SUMMARY MEMORANDUM

TO: El Paso County Board of Commissioners
FROM: Planning & Community Development
DATE: 3/21/2023
RE: SKP-22-005, Jaynes Sketch Plan, N.E.S. Inc.

JAYNES PROPERTY SKETCH PLAN

LETTER OF INTENT MEMO

SKETCH PLAN

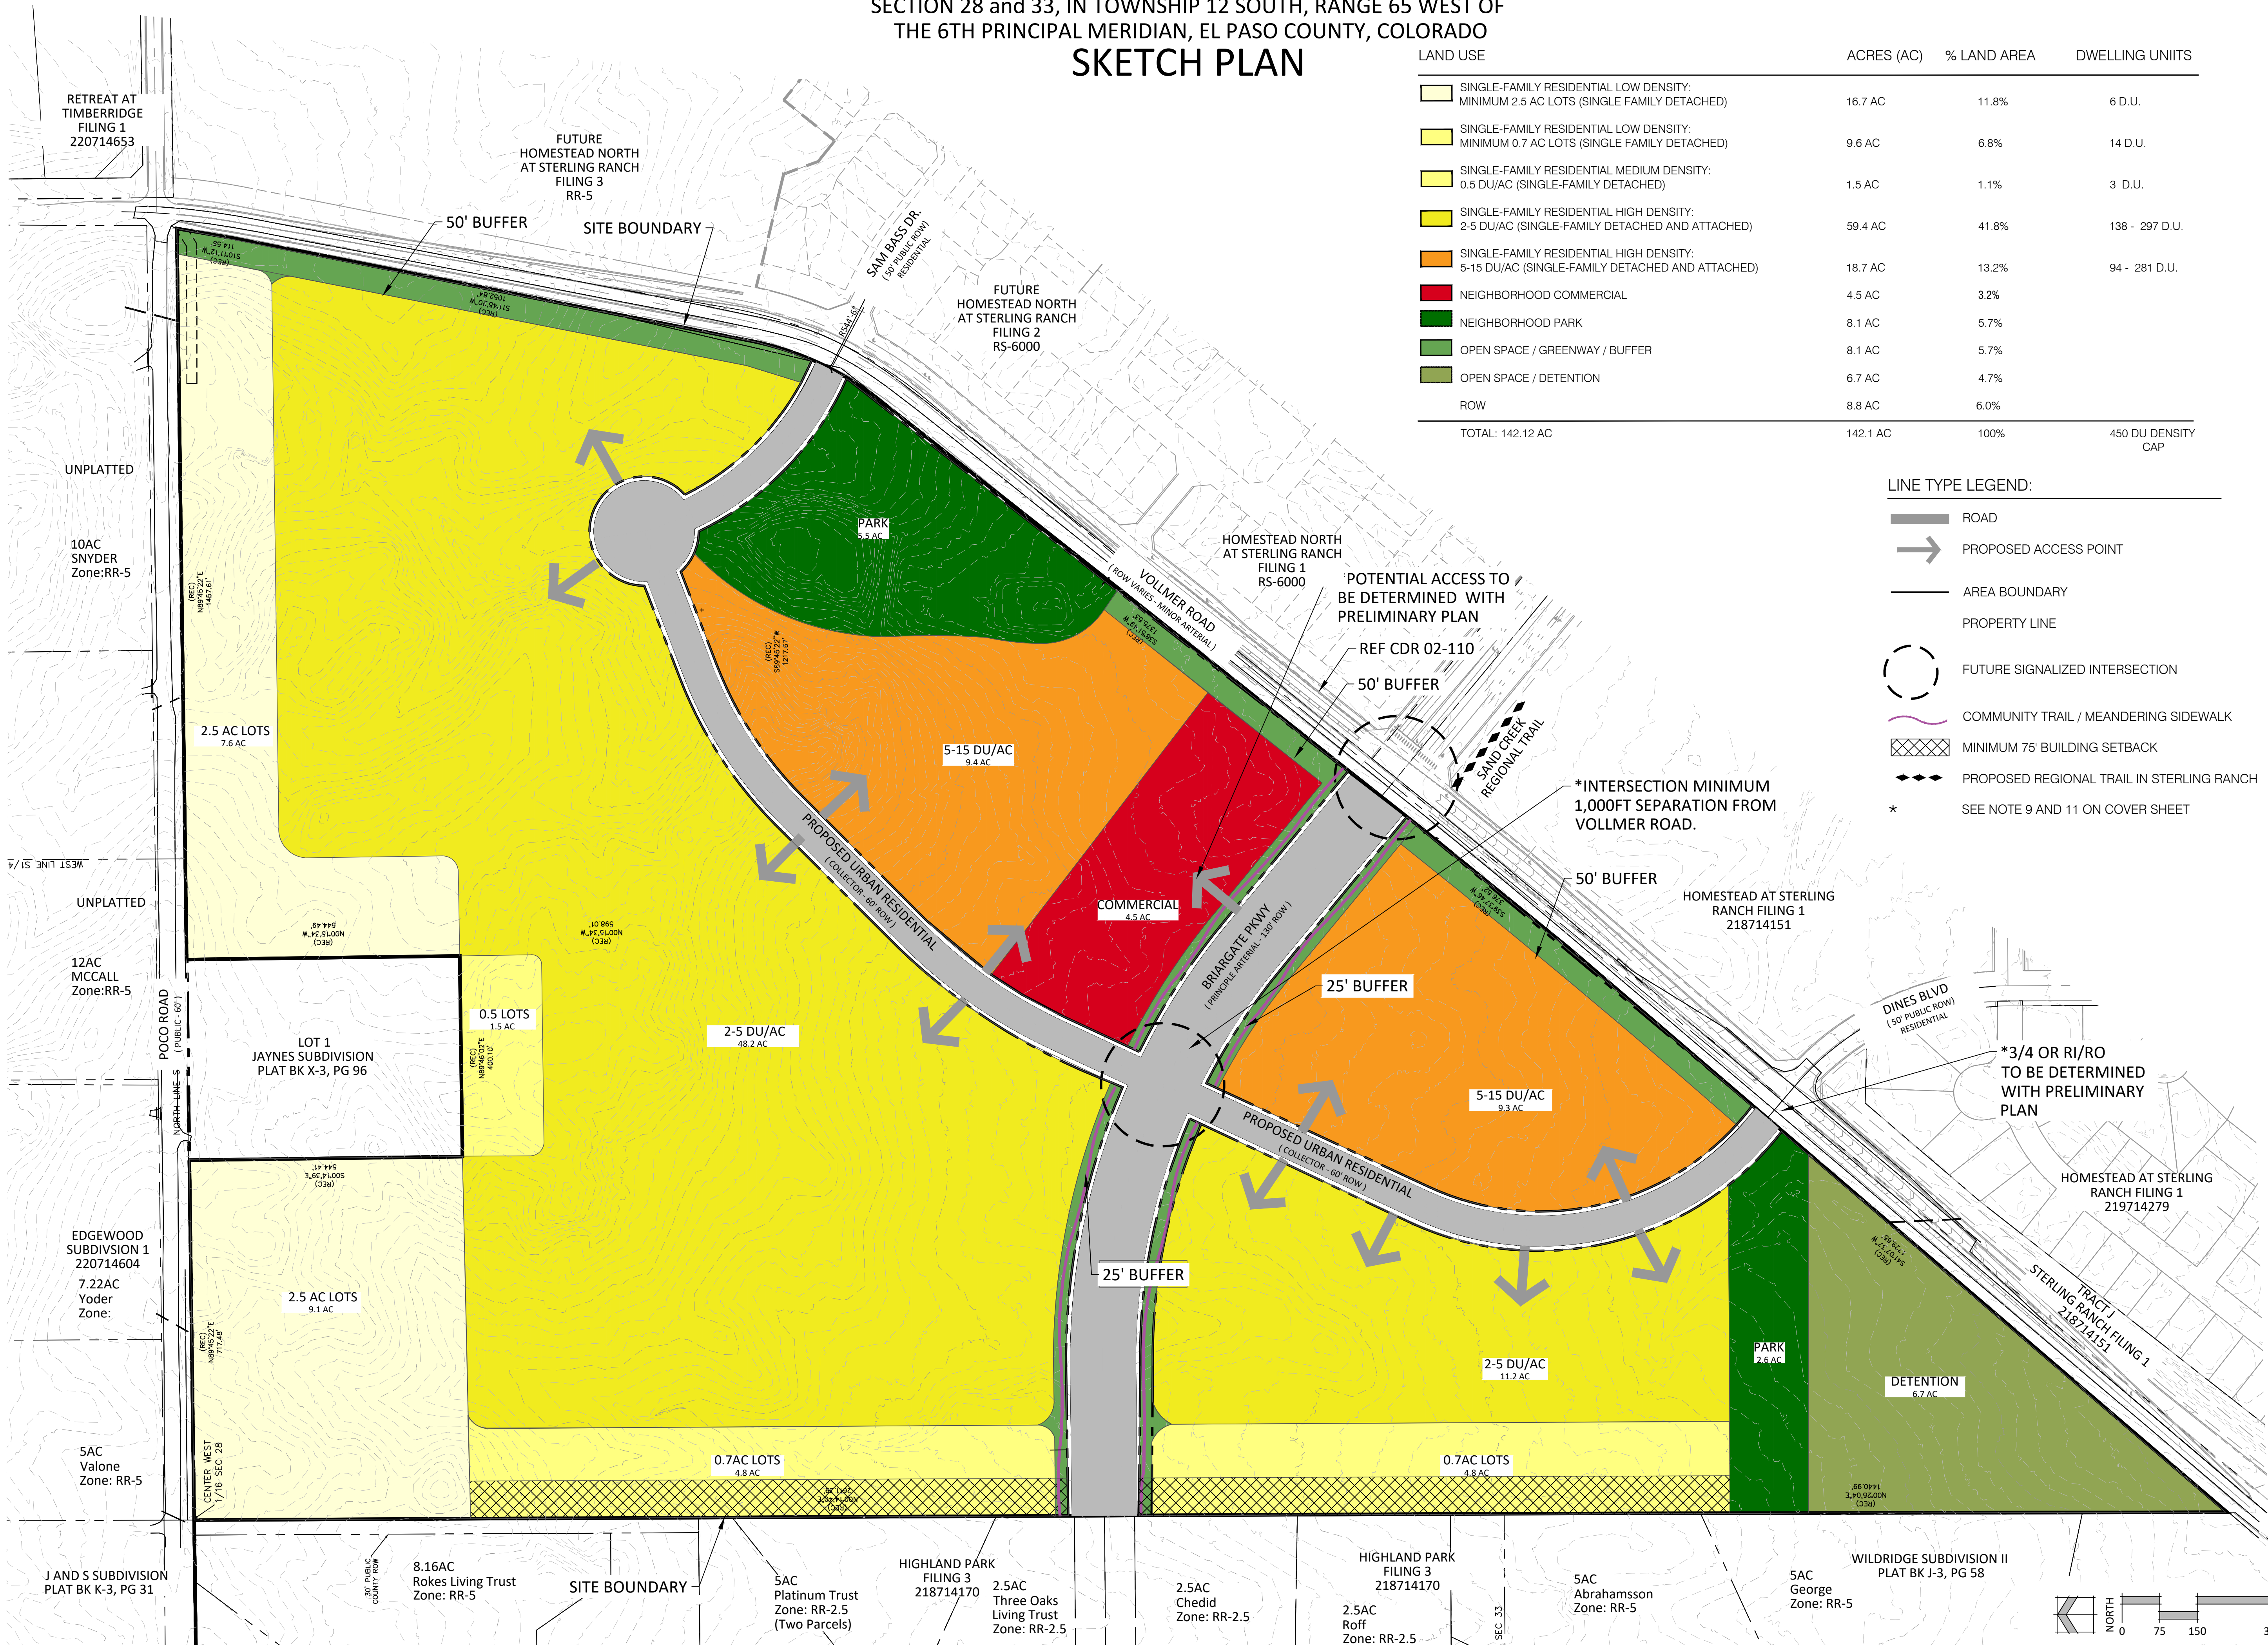
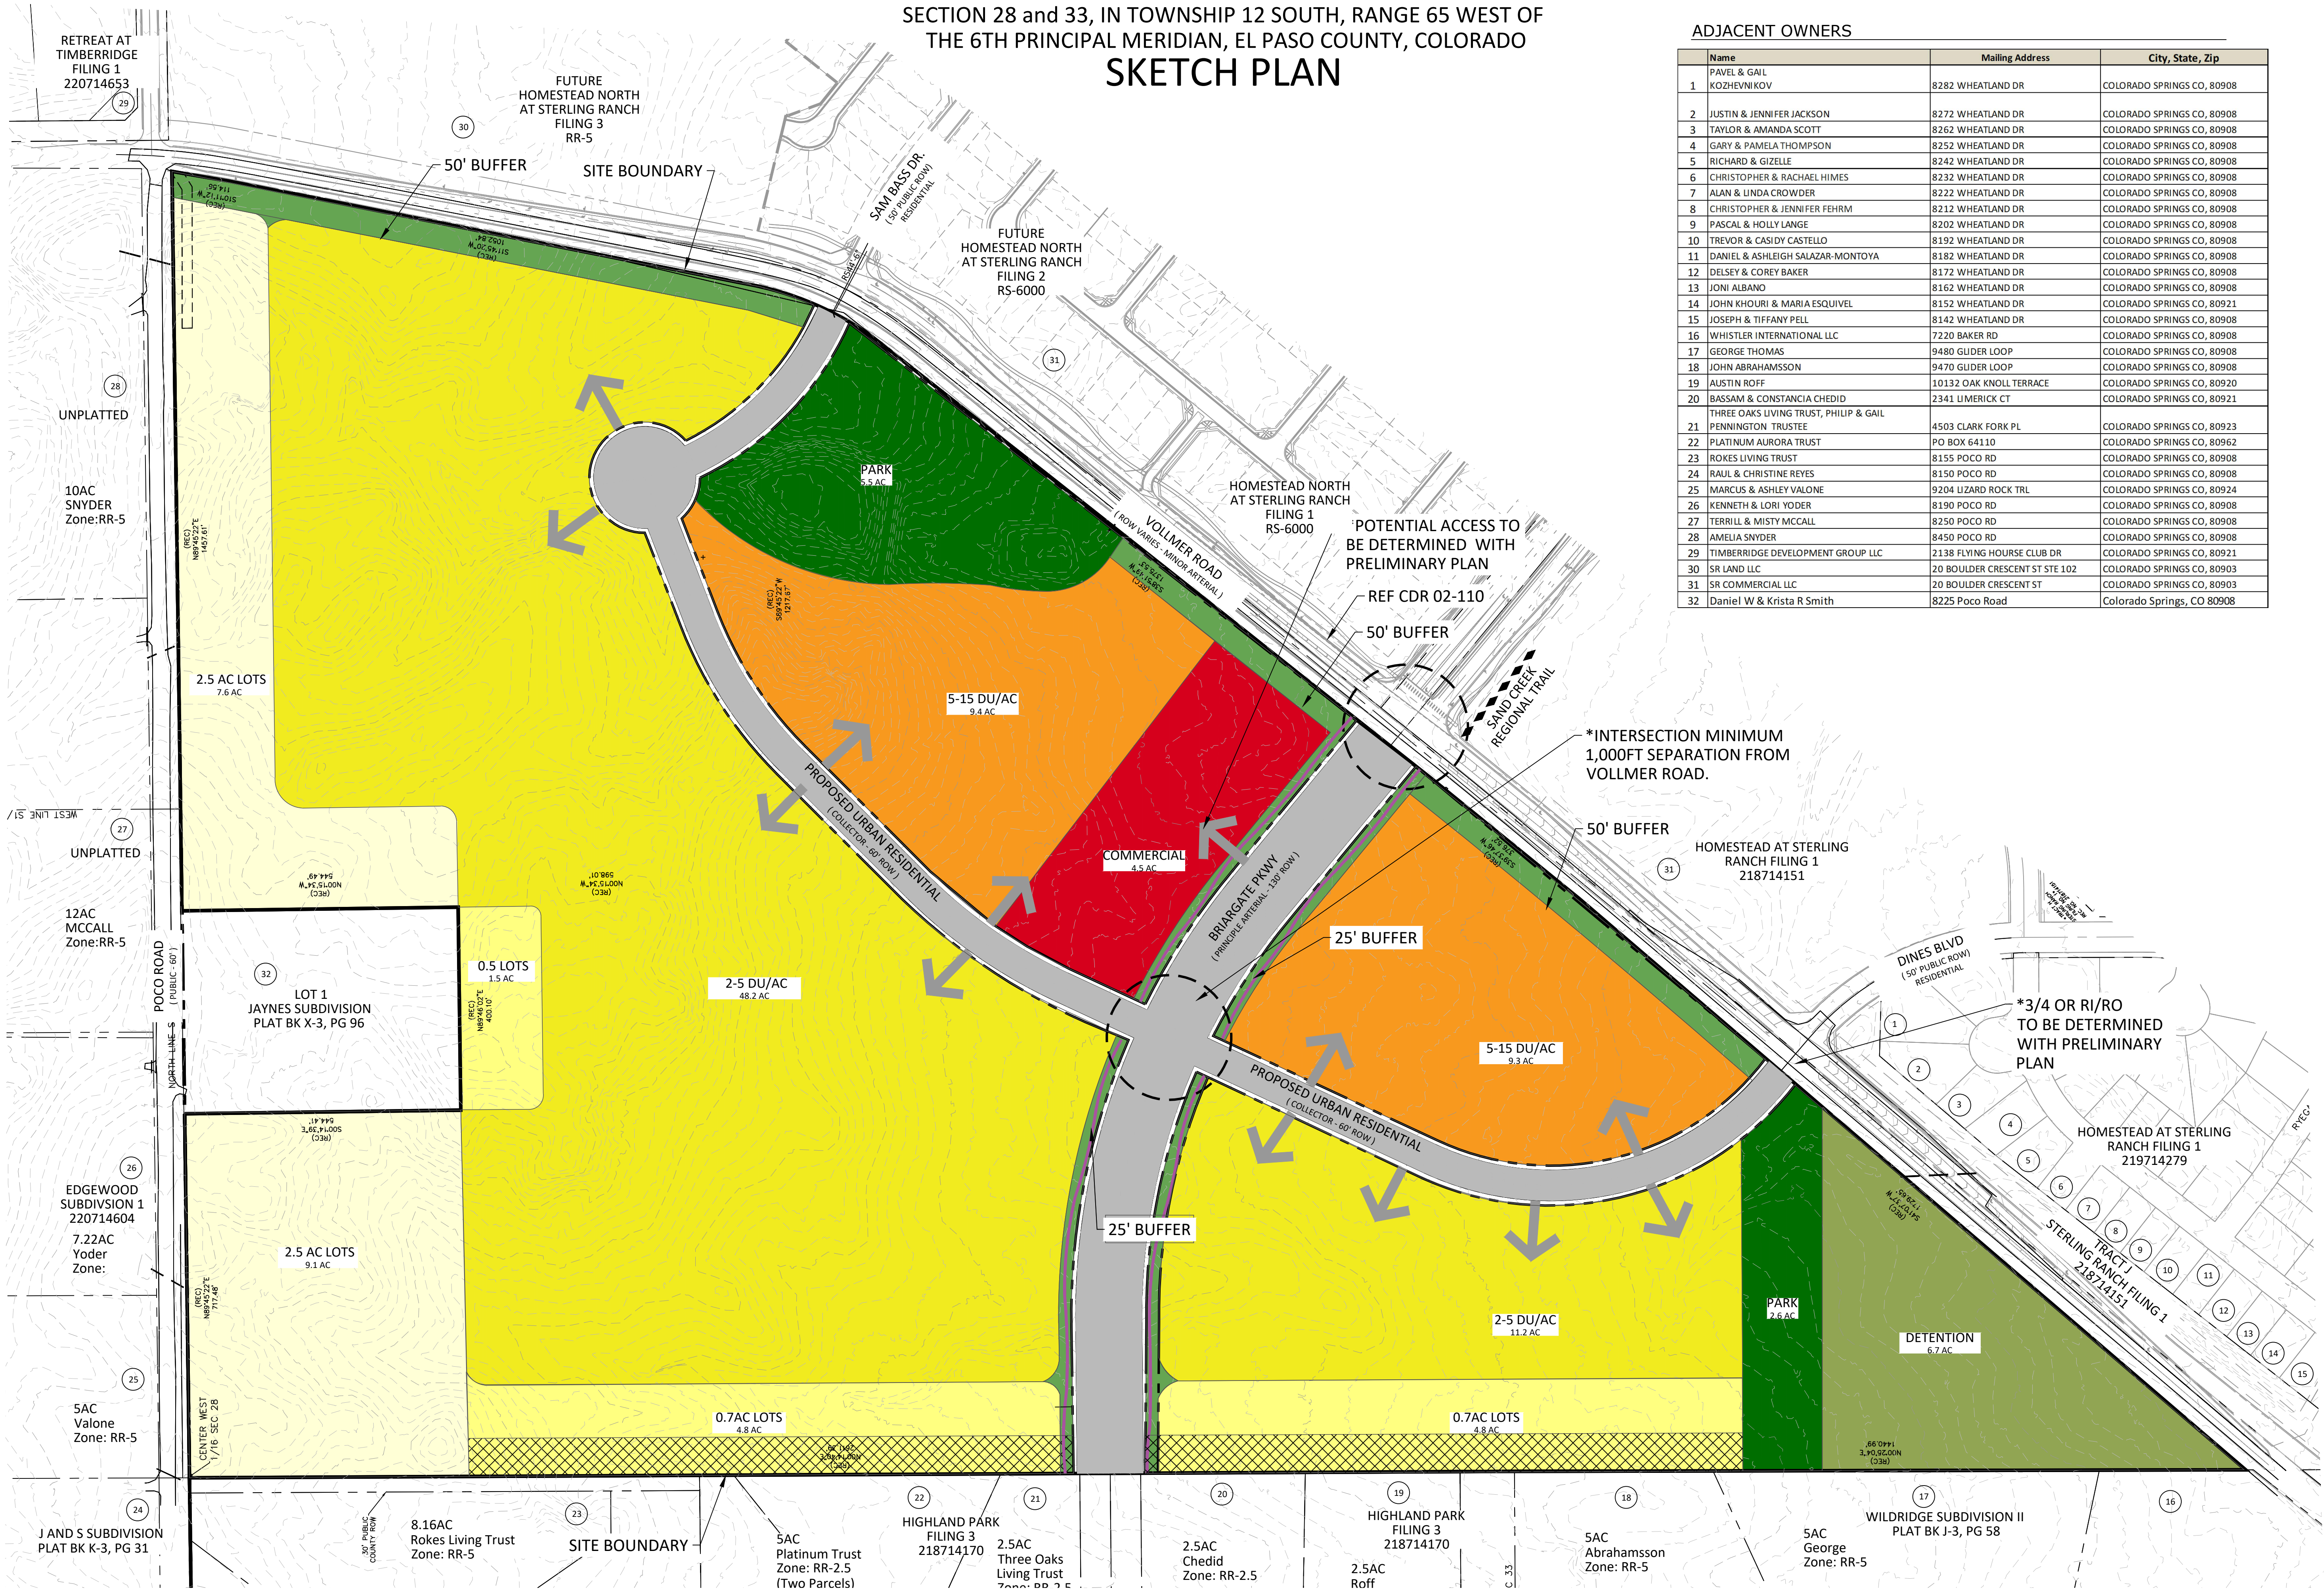
Mr. Carlson stated that RR-5 zoning (5-acre lot size minimum) to 1-acre lots is not a reasonable transition and 2.5-acre lots would be reasonable on the northern boundary. Ms. Fuller agreed with Mr. Carlson and added that 2.5-acre to 0.5-acre lots is not an adequate transition along the west. Ms. Fuller agrees that the higher densities should be internal to the Plan. Mr. Moraes agreed transitions were not adequate at the northern and western boundaries, and pointed out that the existing rural lots adjacent to Poco are larger than the Rural Residential (5-acre minimum) standards. Mr. Whitney agreed with the other members and stated that the sketch plan is the first step in approving the development concept and is important. Mr. Trowbridge stated that the sketch plan is in general conformance with the Master Plan and acknowledged the transitions could be improved. Mr. Bailey stated the transitions are compatible with the surrounding area, and the Master Plan placetype.

Jaynes Property Sketch Plan is amended to reflect comments received on 02/16/23 at the Planning Commission Hearing, relating to density transition from the existing rural residential lots to the north and west. Based on these comments, the following changes were made:

- Revision of 1AC lots along Poco Road to 2.5AC lots
- Removal of the 35' building setback along Poco
- Orientation of 2.5AC lots to match depth of the Smith Parcel
- Removal of the 50' buffer and 35' building setback around the Smith Lot
- Removal of the 50' buffer and trail along the west boundary
- Modification from 0.5AC lots along western boundary to 0.7AC lots with a 75' building setback by incorporating the 50' buffer into the lots.
- Increase in density interior to the site:
 - 5-12DU/AC has been changed to 5-15DU/AC
